**Addendum No. 1**

RE: Contract ID: C201737

**Wake County (R-2809A)**

NC-98 ( Wake Forest Bypass) From West of SR-1923  
(Thompson Mill Road) to US-1

03-DEC-2007 10:59
 C:\cfd\p1\proj\001\proj\001\traffic\trafficcontrol\tcp\2809a\to-phl_tcp06.dgn
 s06d1s - A1 WZ1237457

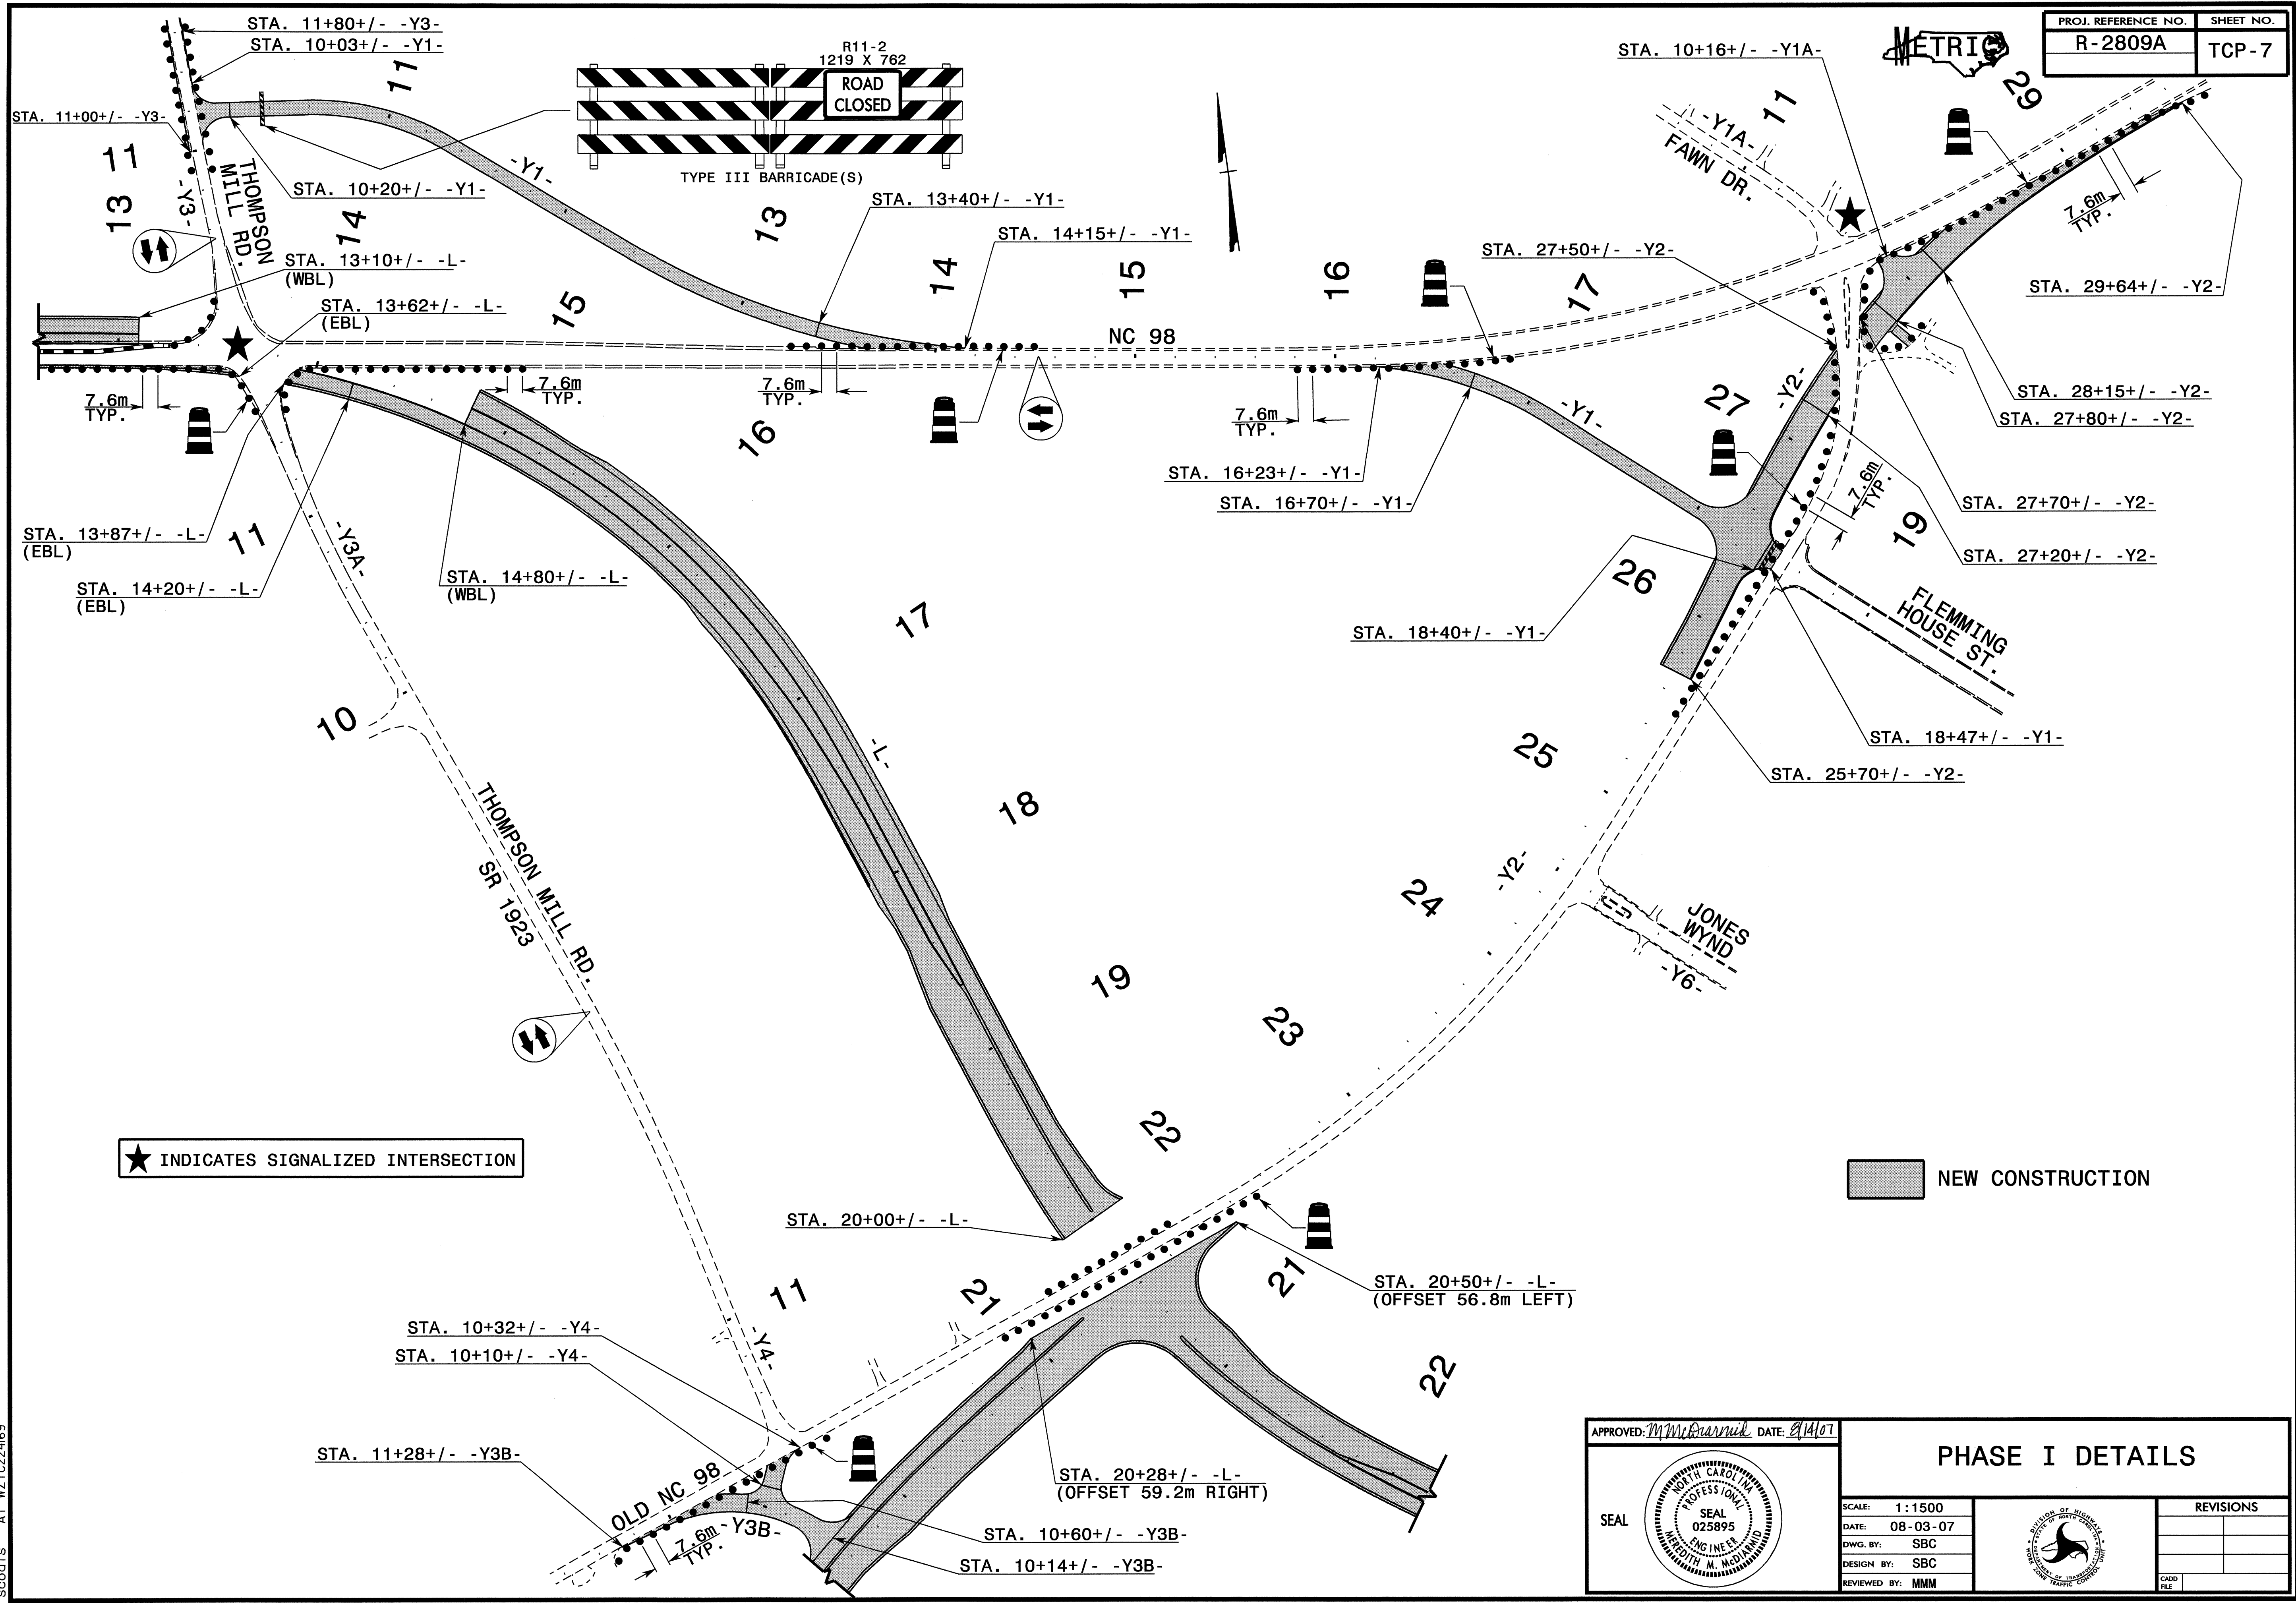
Plan Sheet Nos. TCP-3 and TCP-6 have been revised to include phasing and pavement marking details for the installation of a temporary traffic signal at SR-4535 (Retail Drive). This temporary traffic signal will provide for the safe movement of construction vehicles leaving the project. Please void Sheet Nos. TCP-3 and TCP-6 in your plans and staple the revised Sheets Nos. TCP-3 and TCP-6 thereto.
